THE
ASTOR

25 October 2017

**Re: InterContinental Hotel and Transport House, Sydney – Concept Development
Application (Staged Development) for Alterations and Additions (SSD 7693)**

TITLE
LEVEL 08 / 08A - PLANT ROOM
FLOOR PLAN SHOWING NEW ELEMENTS

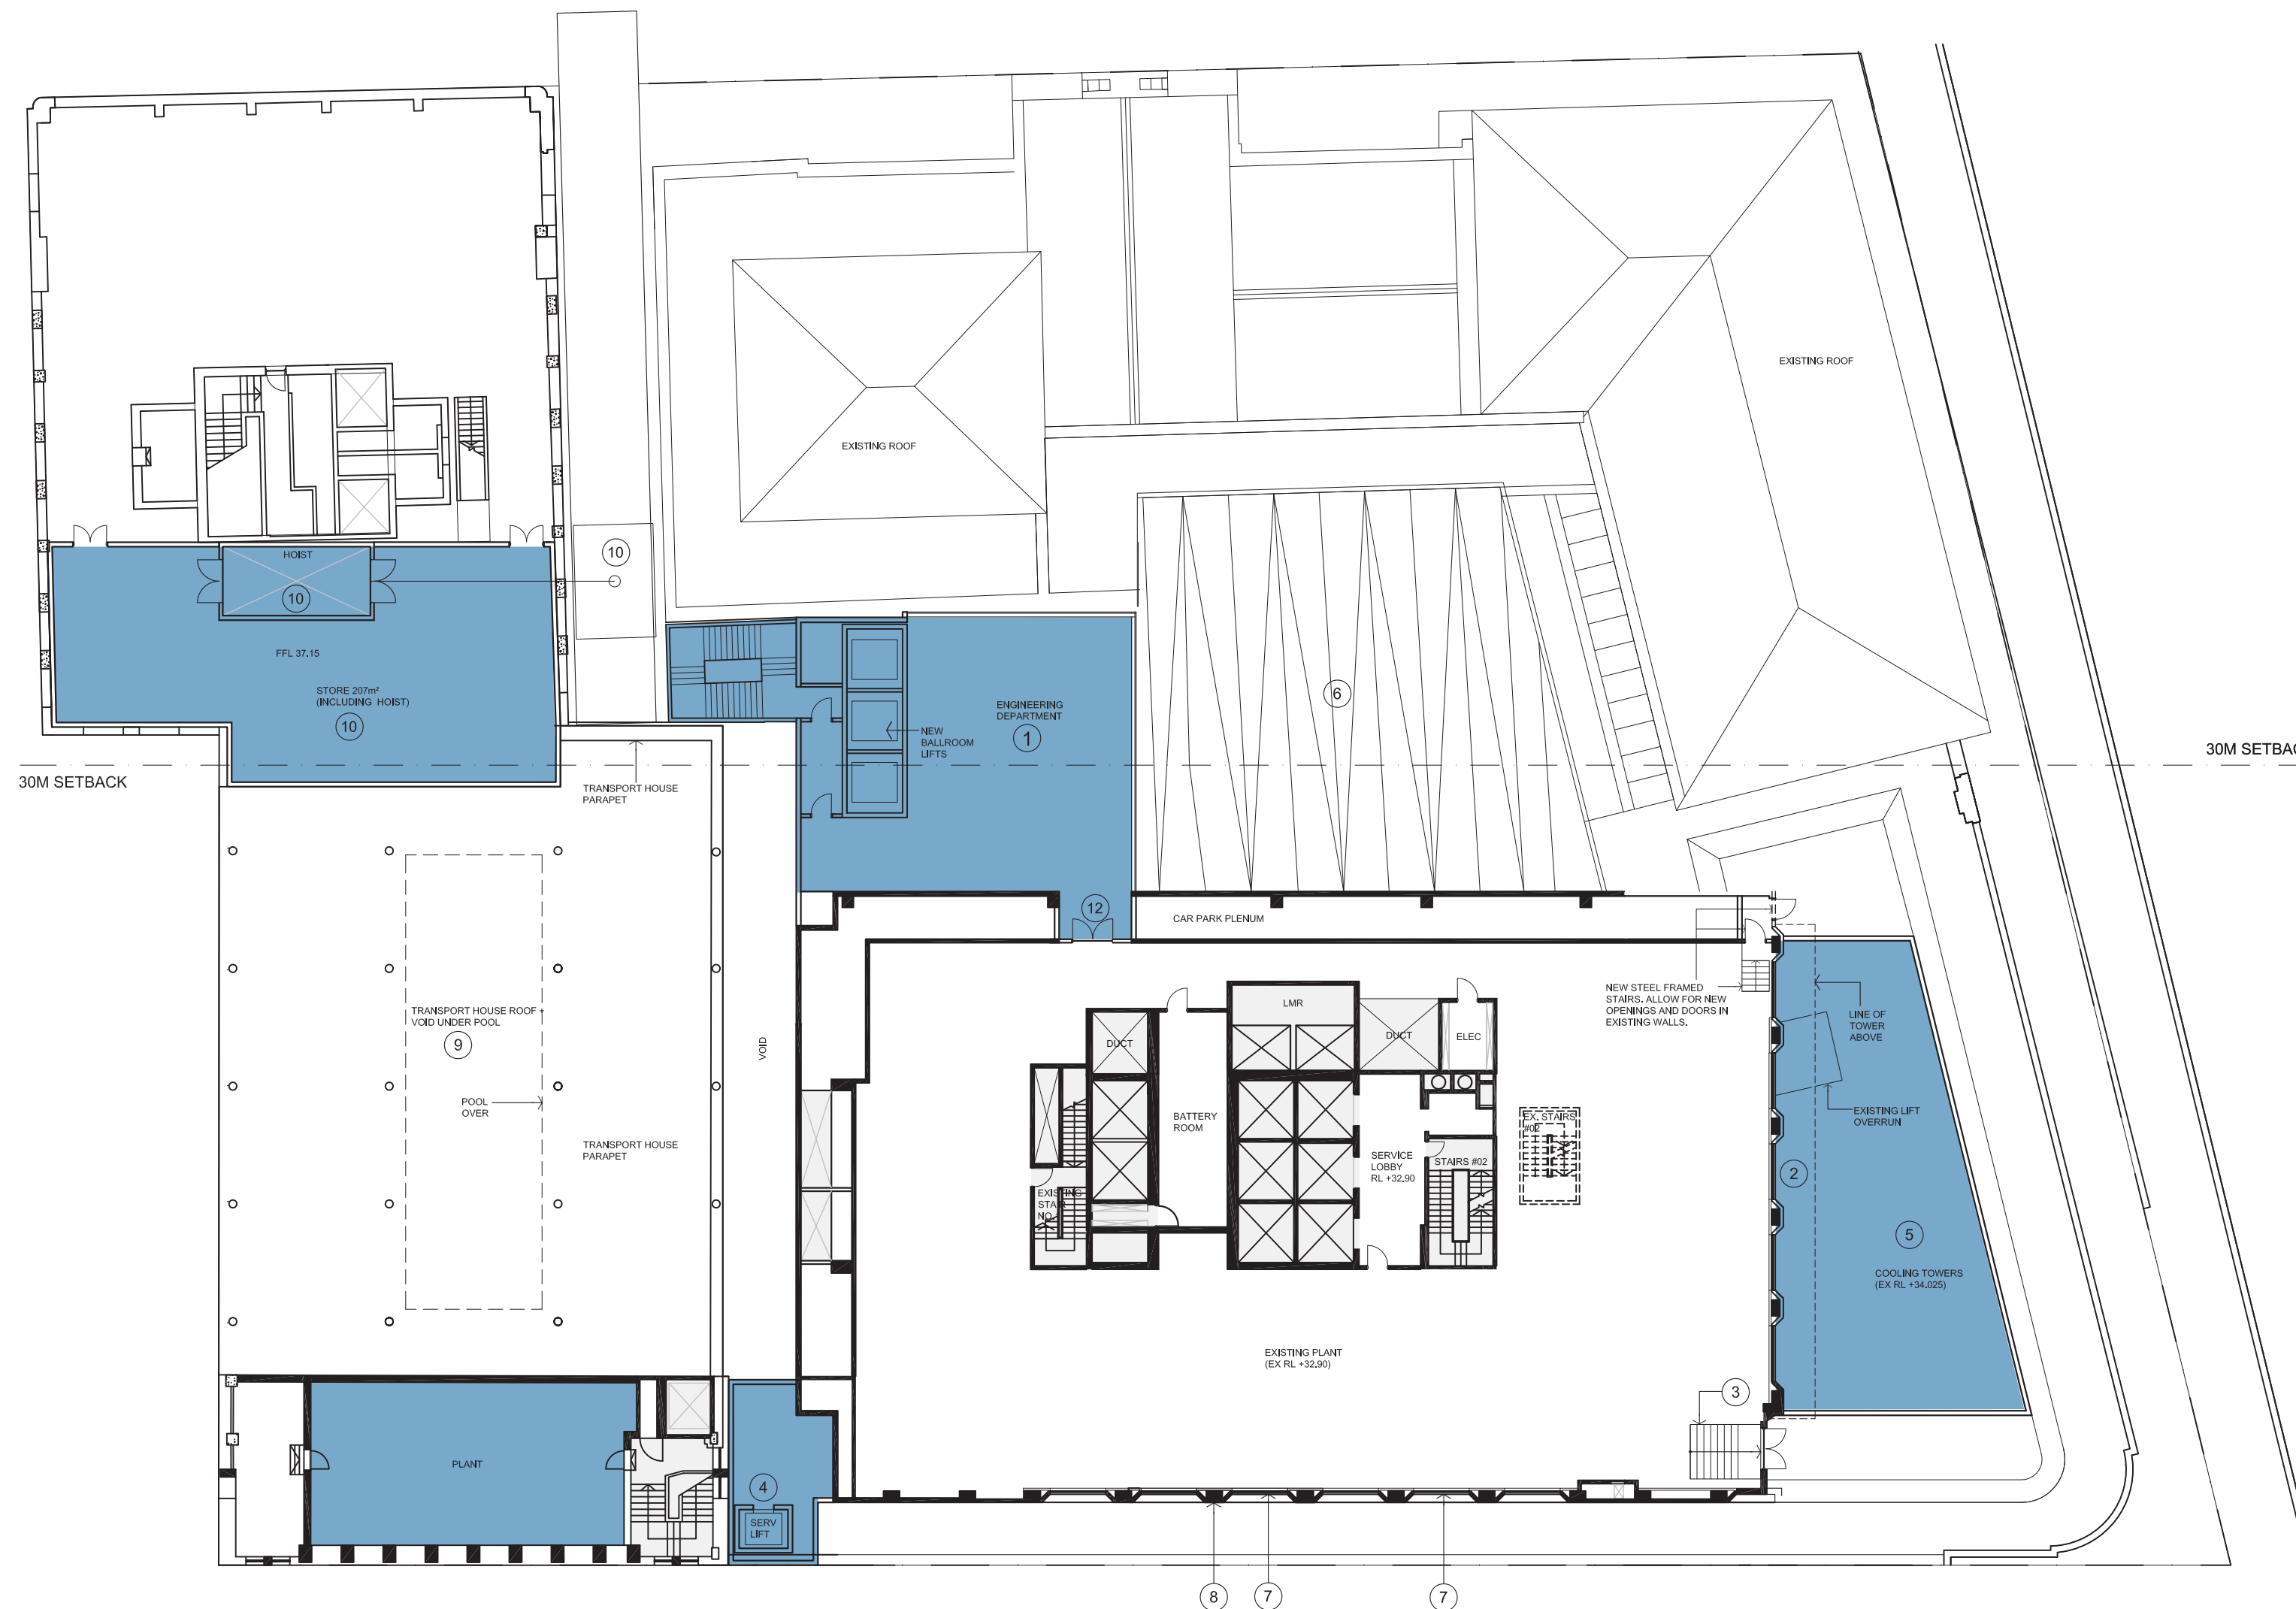
As evidenced in the Visual Impact Study, the re-location of cooling plant to level 8 of the South Elevation is visually prominent and detracts from the heritage façade of the Treasury building.

SETBACK DIAGRAM | VIEW FROM NORTH-EAST

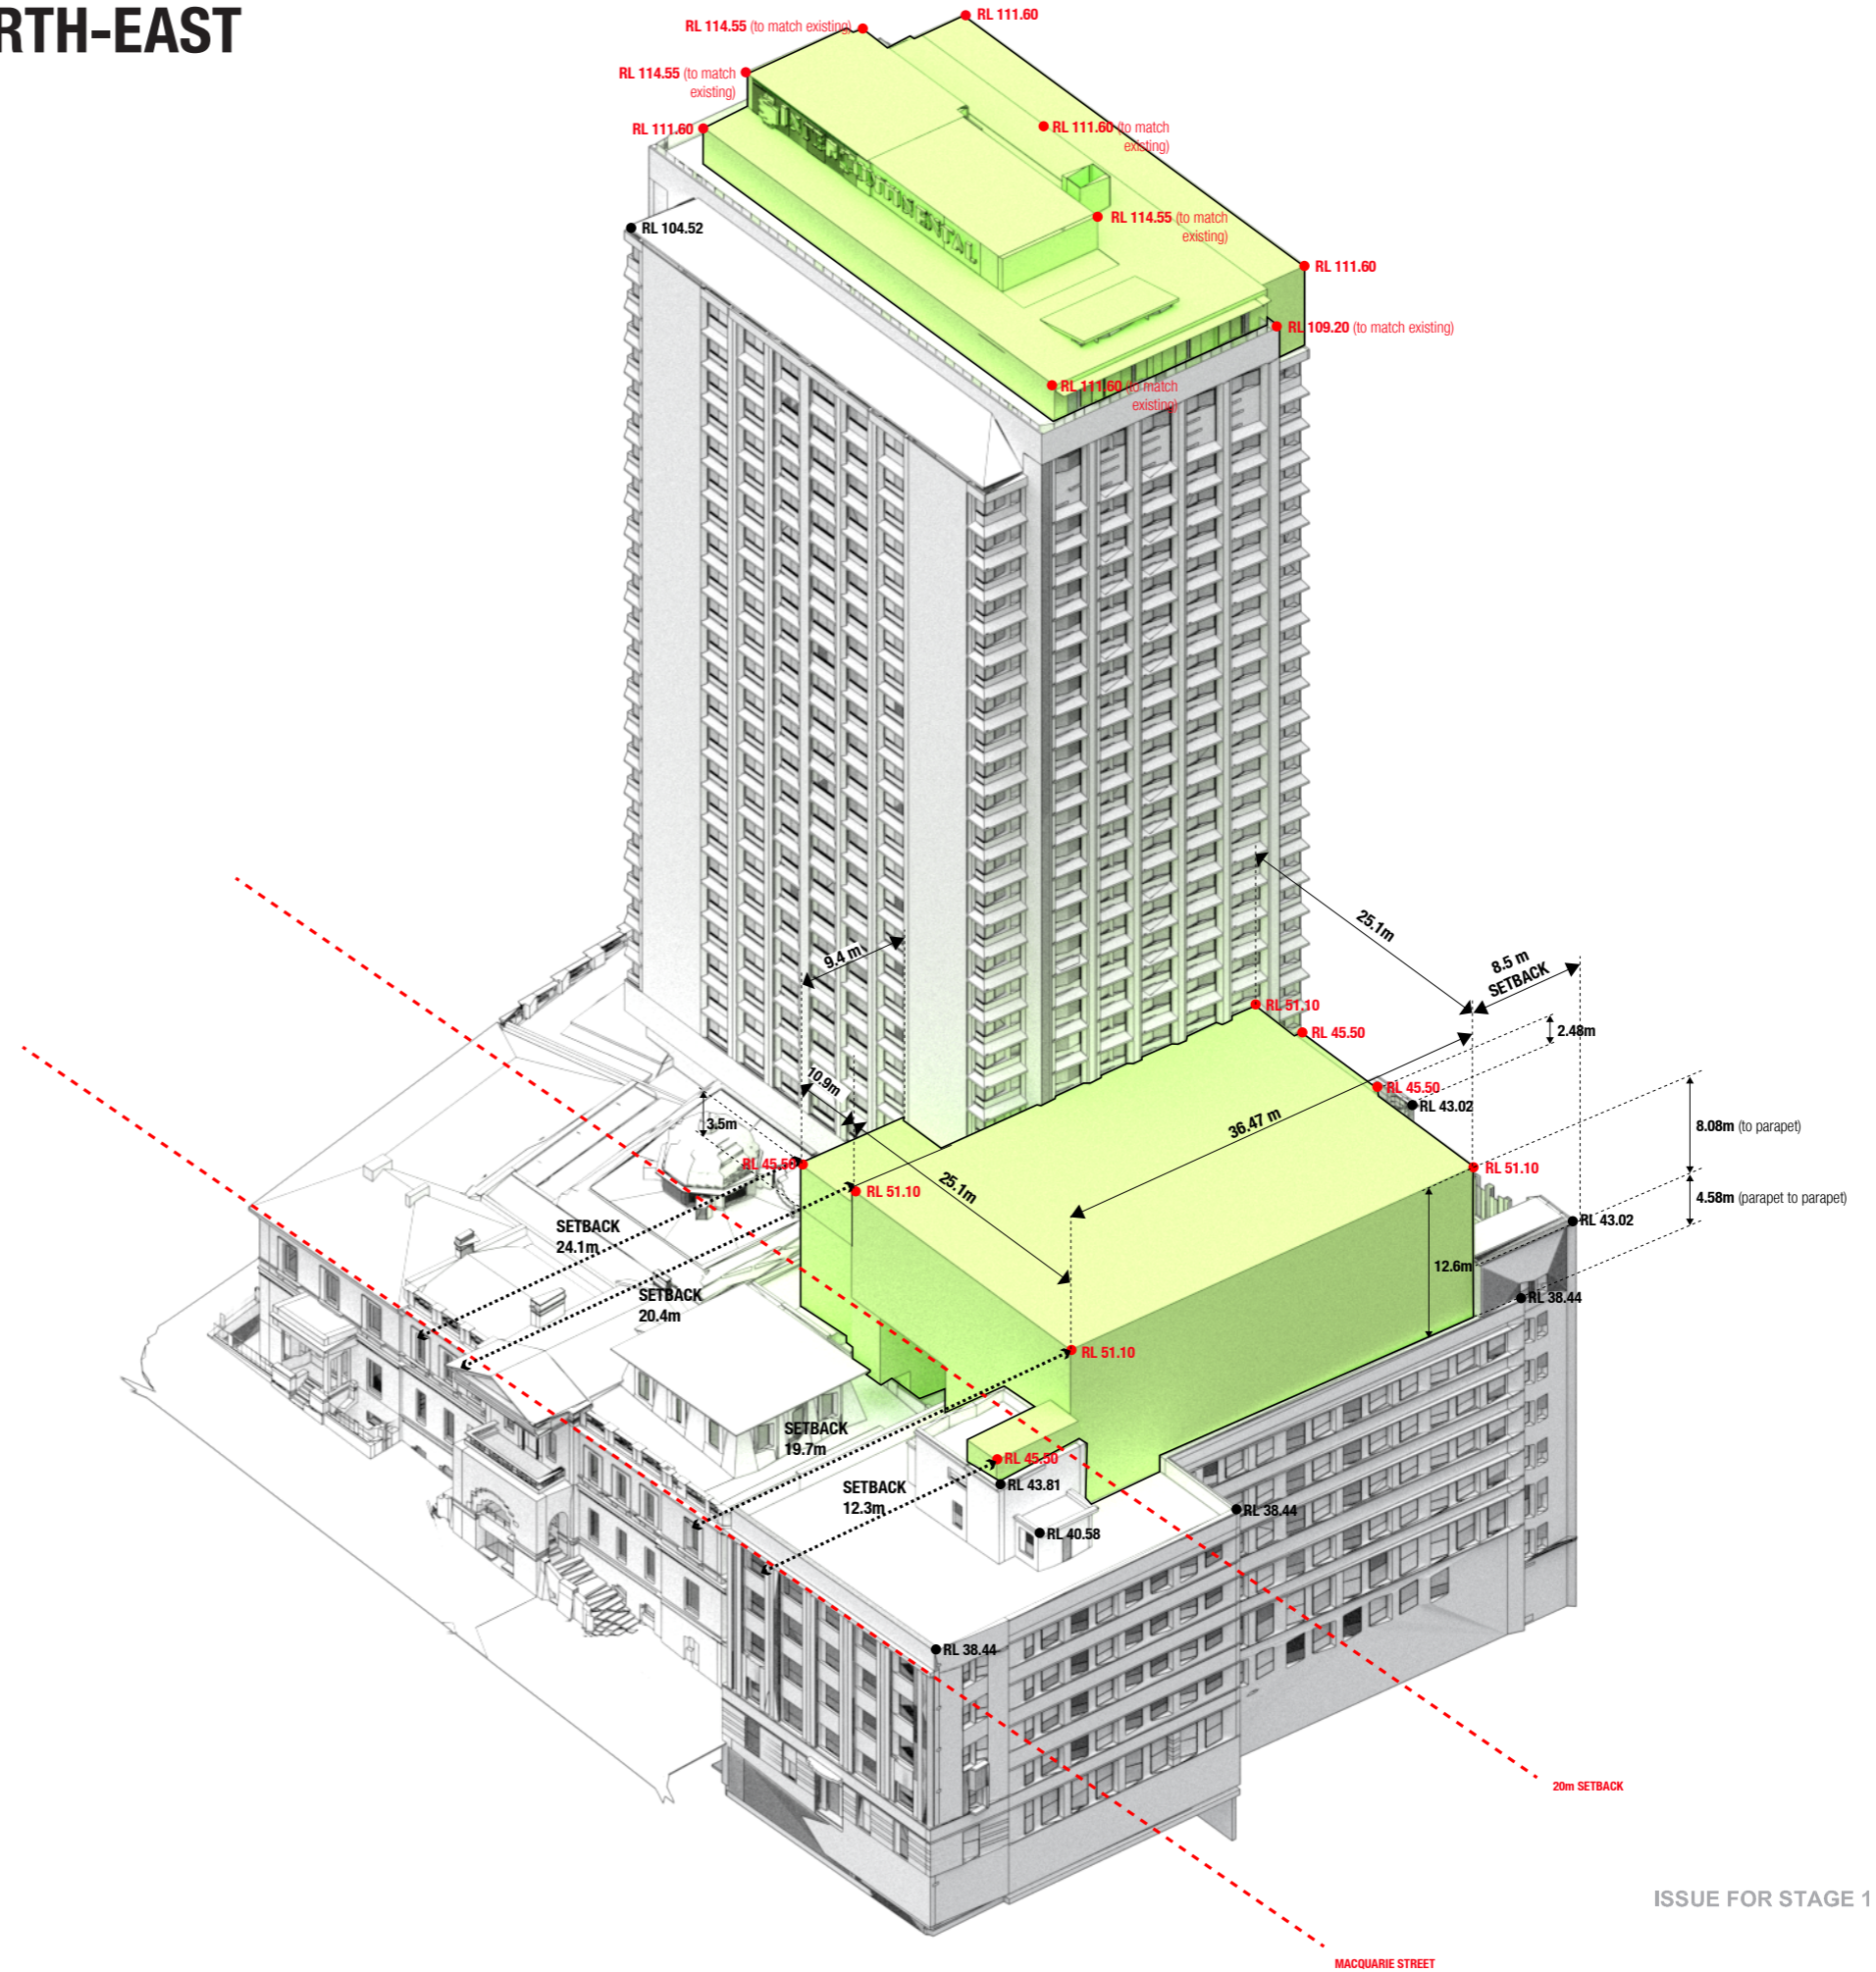
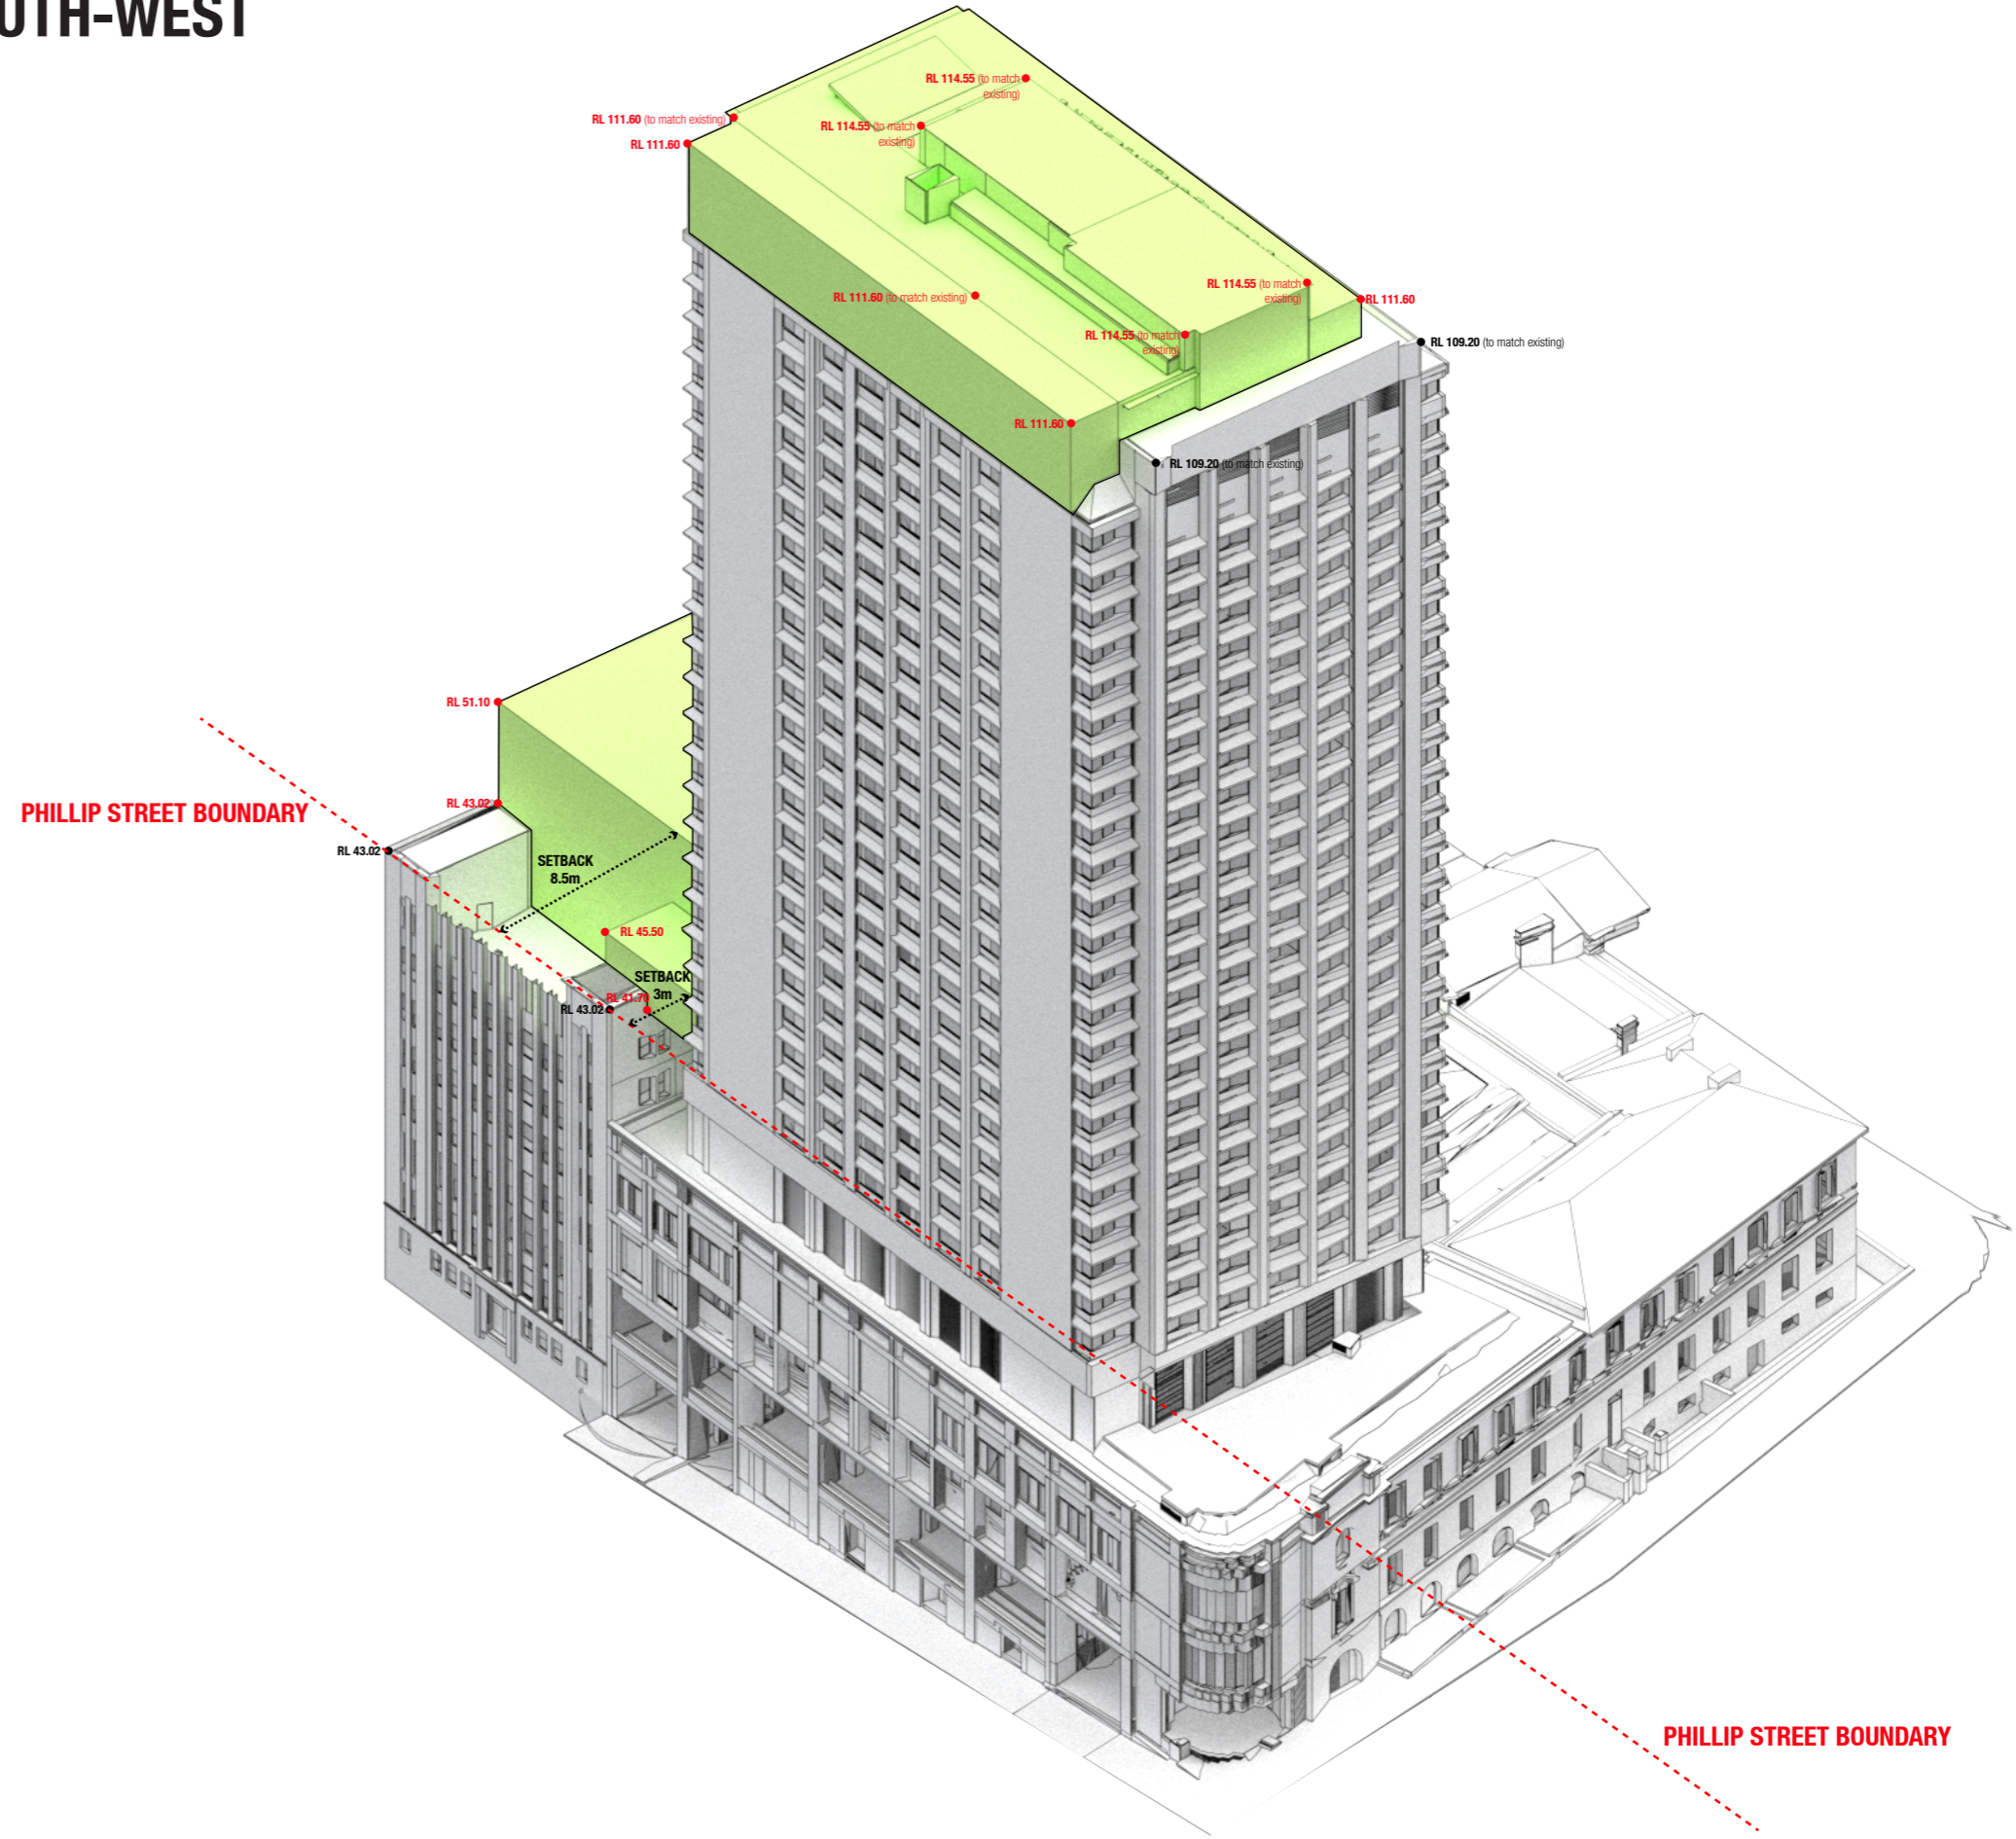
Given that the proposed works are located in a Heritage Conservation Area, it is vital that existing setback controls in place are complied with to maintain the important heritage features and streetscape.

Specifically, the proposed additions should comply with:

- the 30 metre front setback control from Macquarie Street in the Special Character Area and
- the 10 metre setback from the Phillip Street Wall.

To not comply with existing setbacks will overwhelm and detract from the heritage buildings on which the proposed building envelope sits, and generally, the heritage streetscapes in the Macquarie Street Special Character Area.
